National Infrastructure
Planning
Temple Quay House
2 The Square
Bristol, BS1 6PN

Our Ref: EN010148

Date: 15 August 2025

Application by RWE Renewables UK Solar and Storage Limited for an order granting development consent for the Tween Bridge Solar Farm project.

Environmental Statement Appendix 7.7: Great Crested Newt Presence / Absence Survey Report

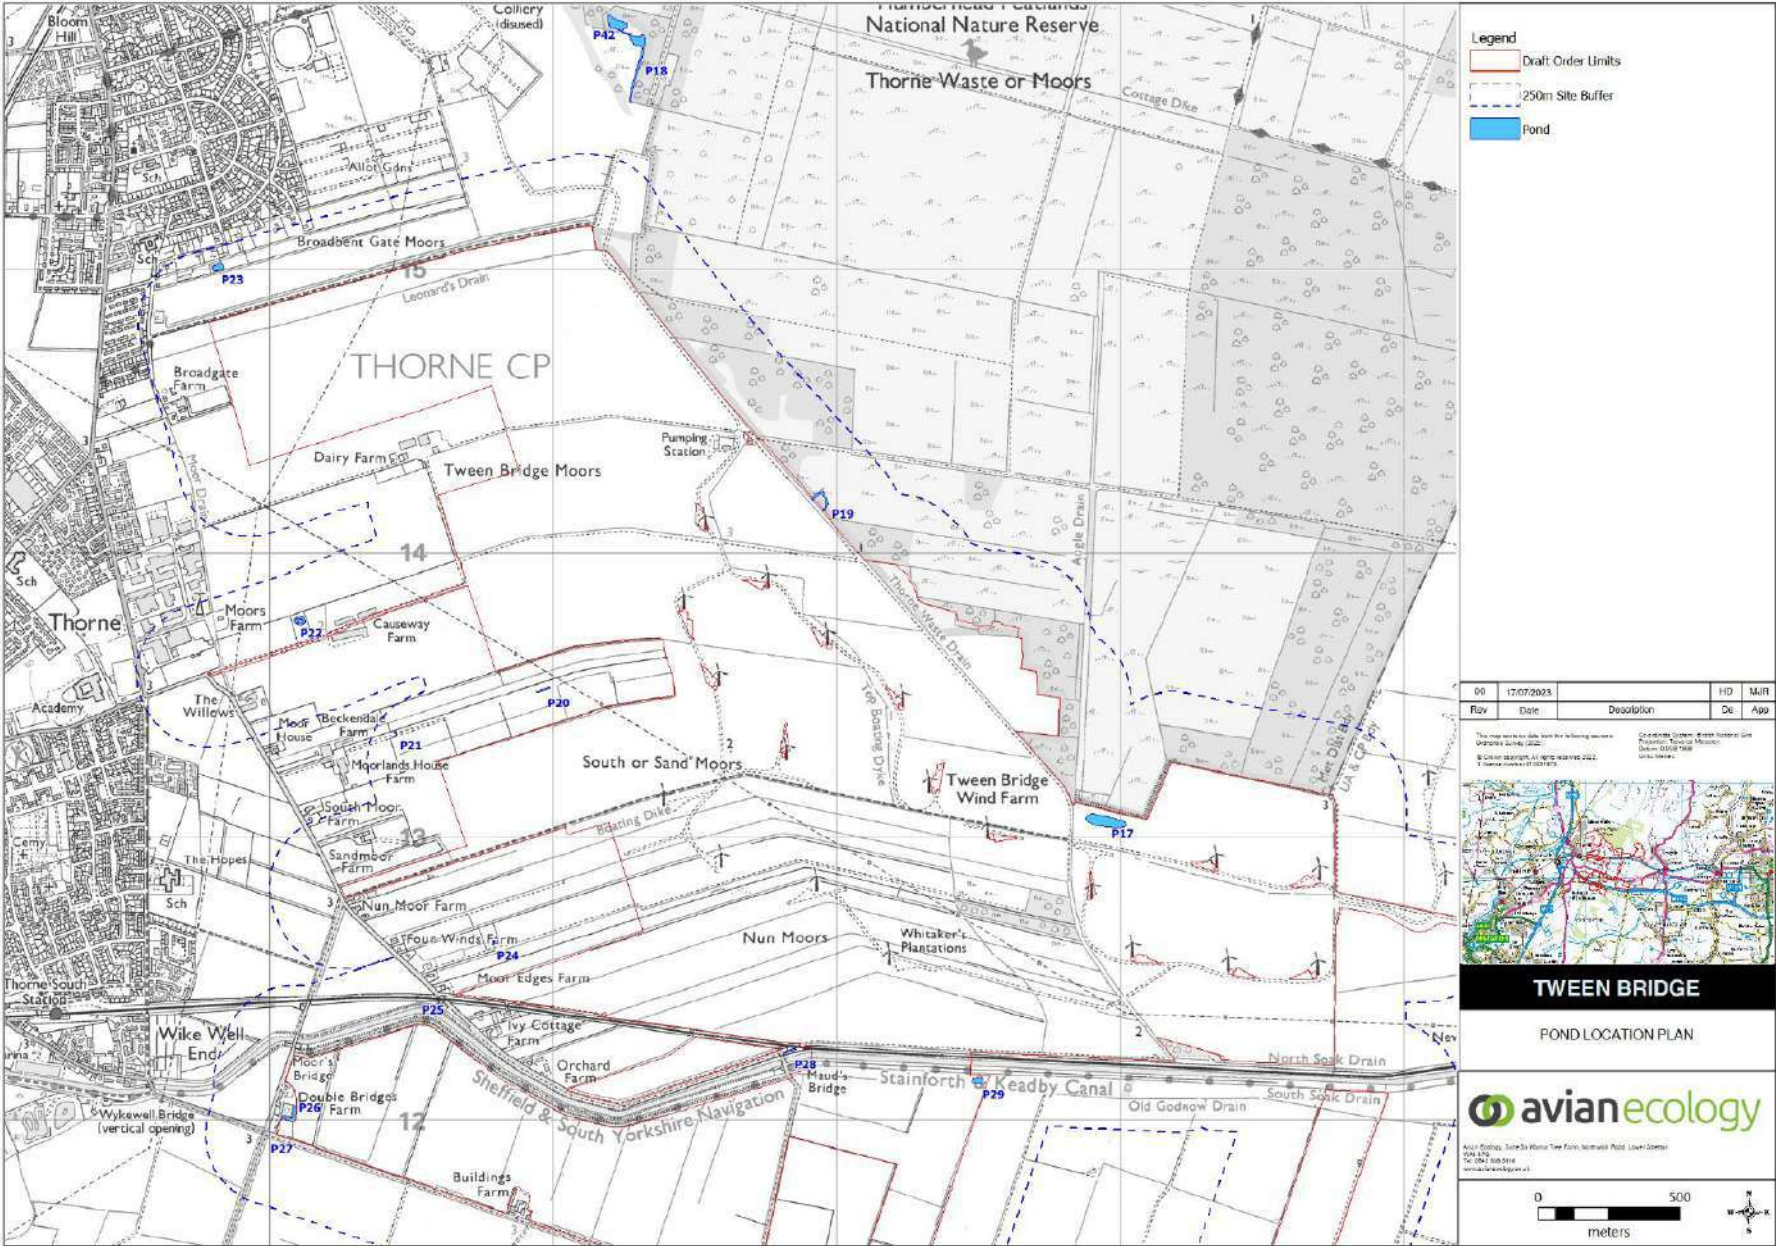
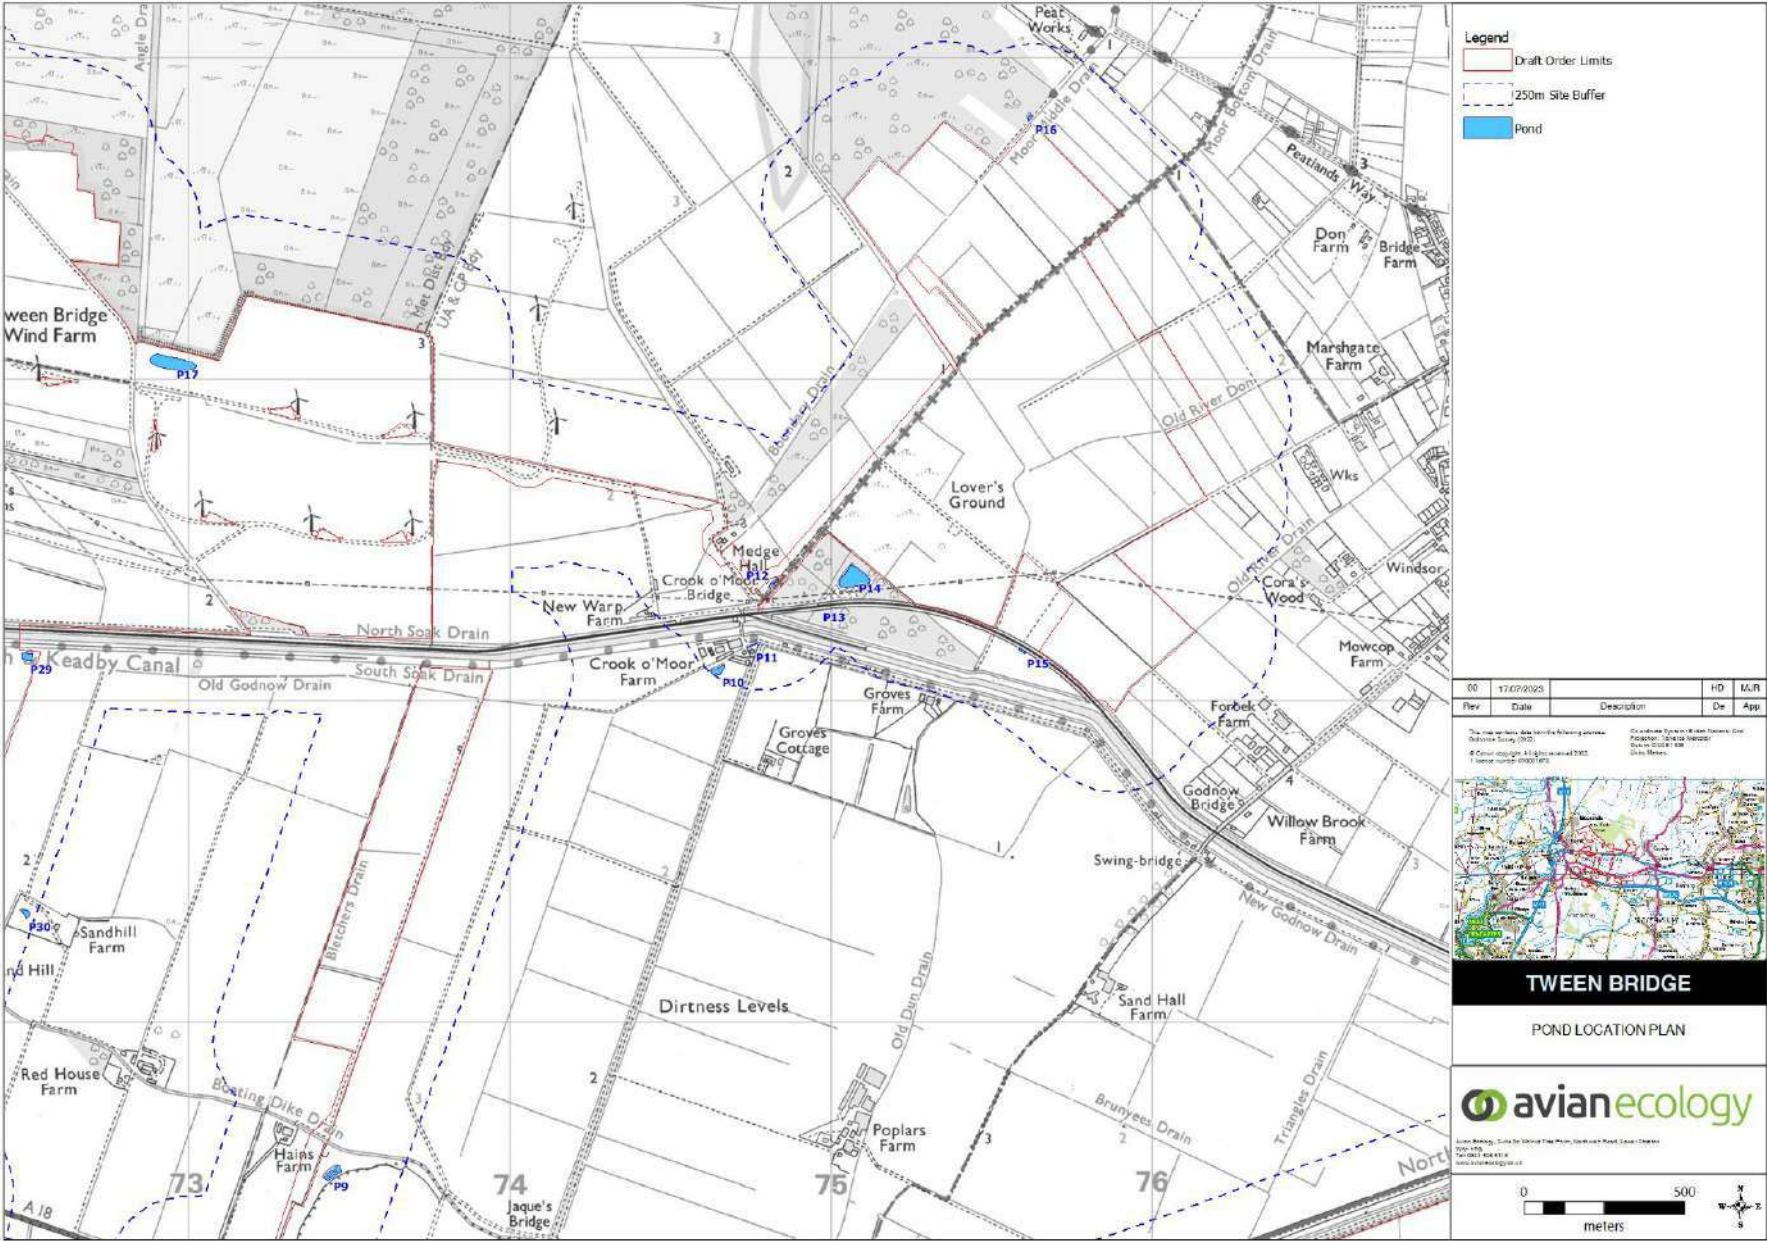
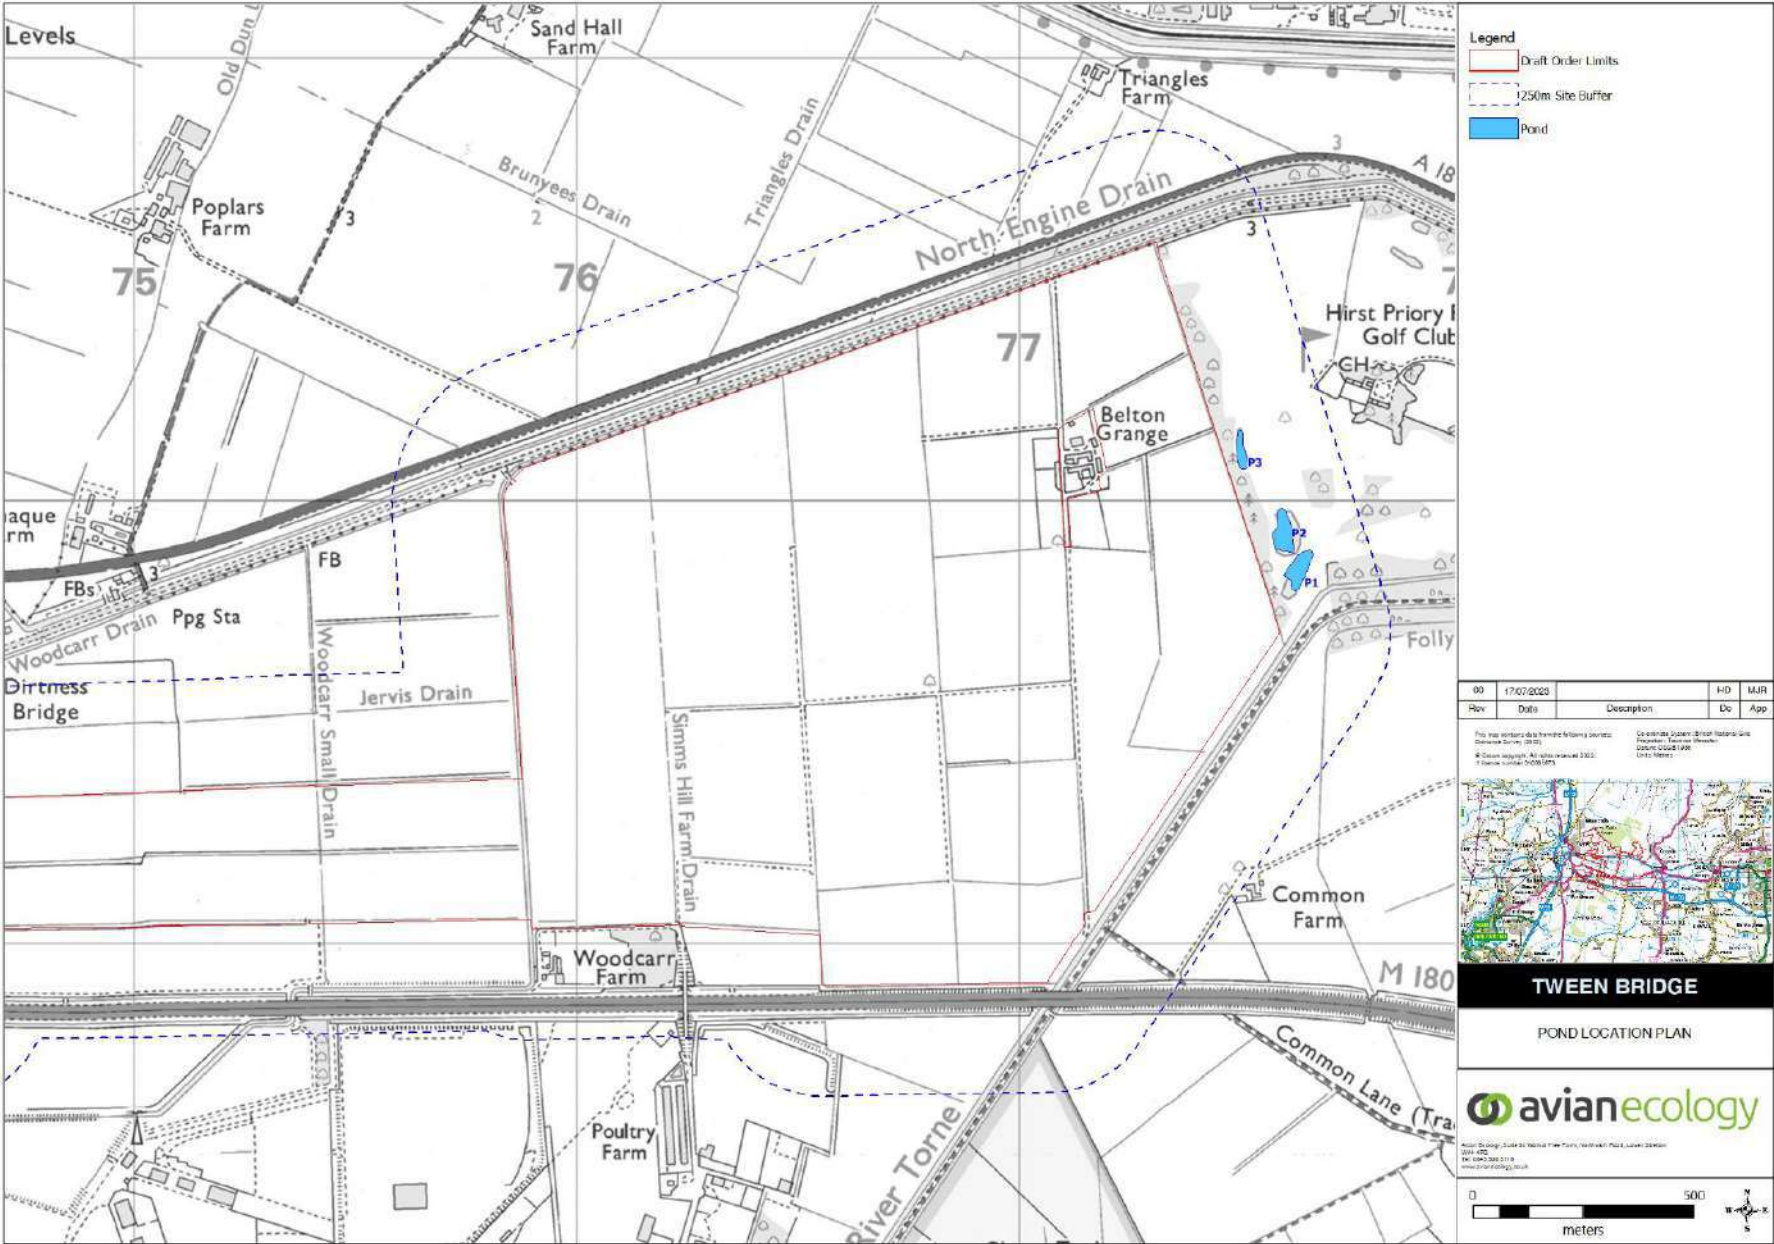
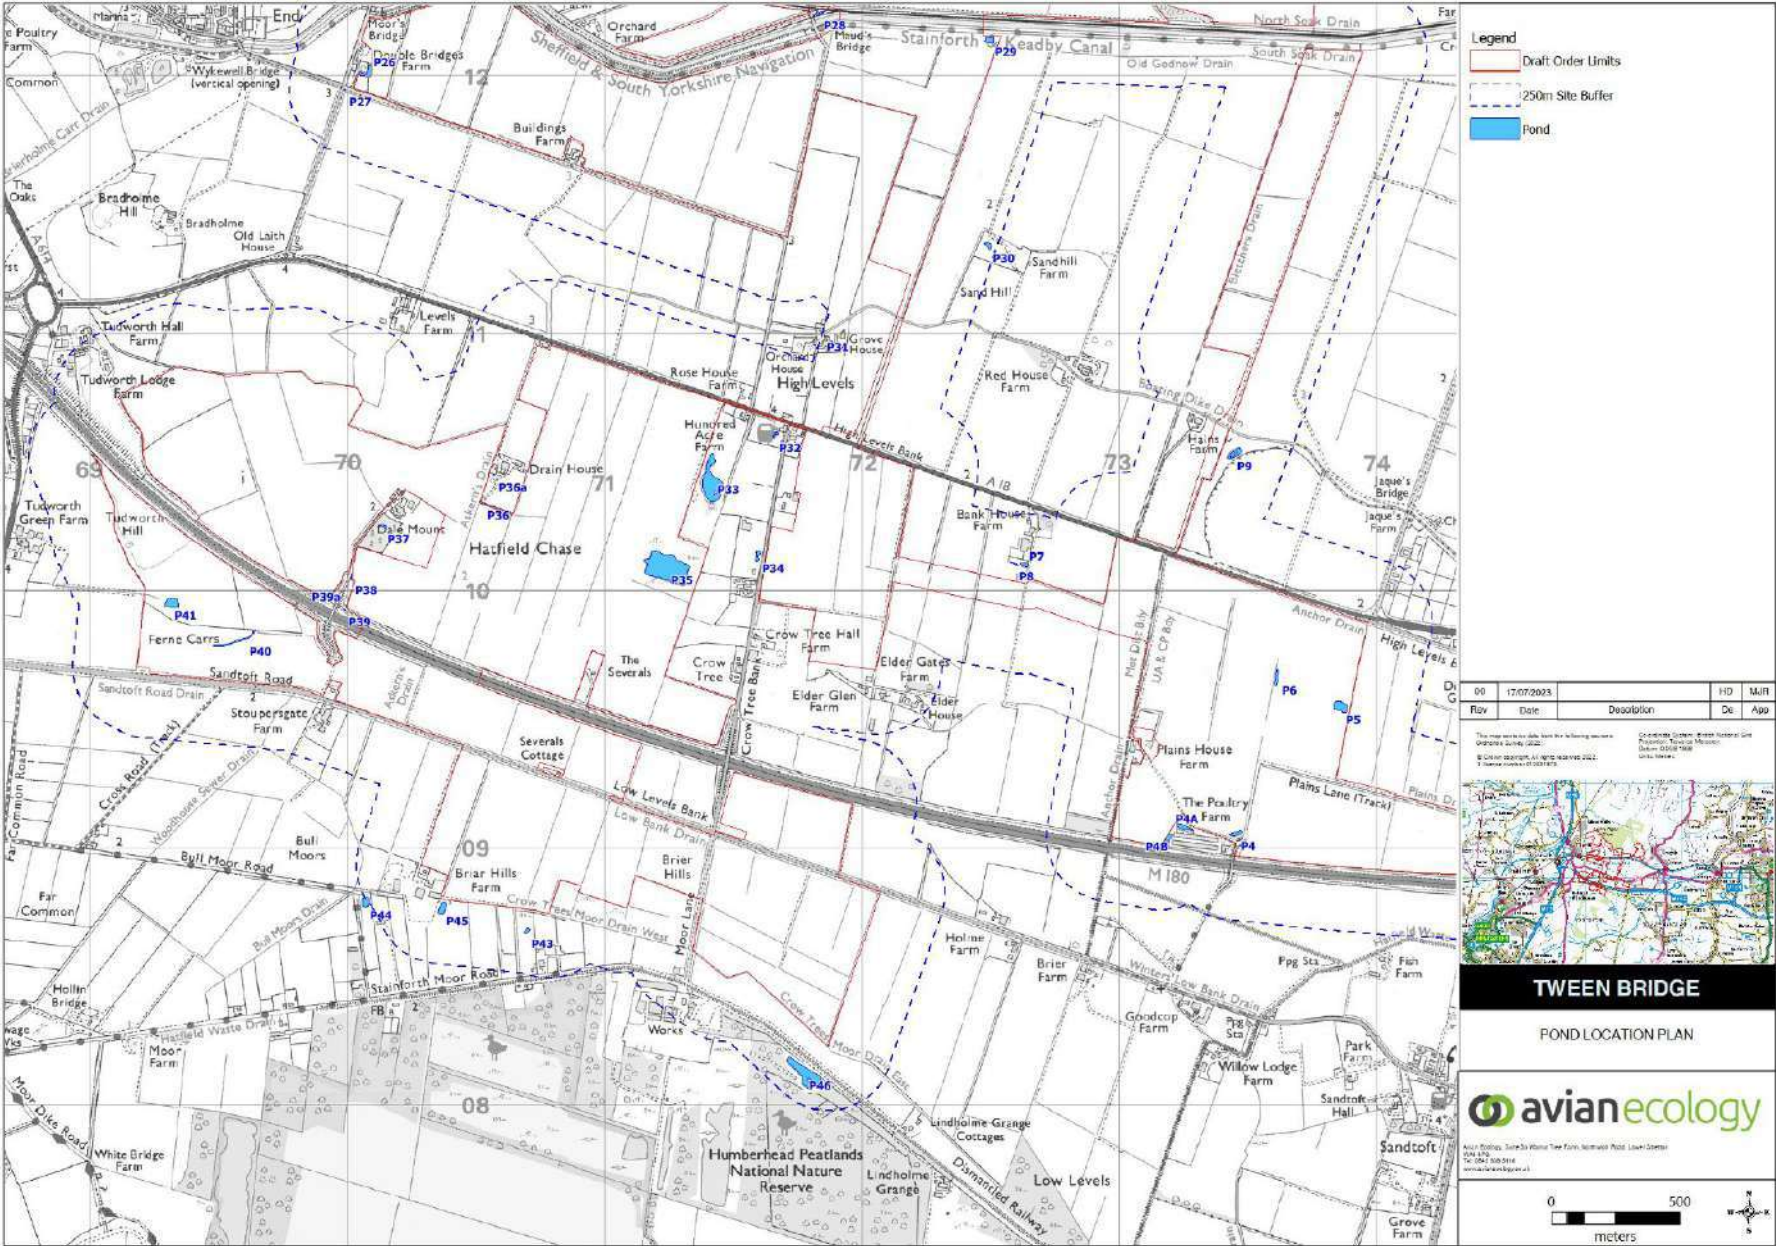
- Doc 6.3.7.5 ES Appendix 7.5 Badger Surveys
- Doc 6.3.7.7 ES Appendix 7.6 GCN surveys
- Doc 6.3.7.10 ES Appendix 7.10 Non breeding bird mitigation
- Doc 6.3.7.11 ES Appendix 7.11 Invertebrates (area not given)

- updated Great Crested Newt (GCN) Surveys, to provide updated data compared to the 2023 surveys; and
- breeding bird surveys of land not previously covered during surveys.

The applicant is advised to take into account the absence of the requisite detail in the ES chapters given the omissions in the appendices and figures identified above to ensure that all assessments undertaken in the ES fully reflect all potential receptors or the zone of influence for the proposed development. The applicant is advised that this should be addressed and updates be made, as necessary, to the assessments within the ES and any relevant application documents.
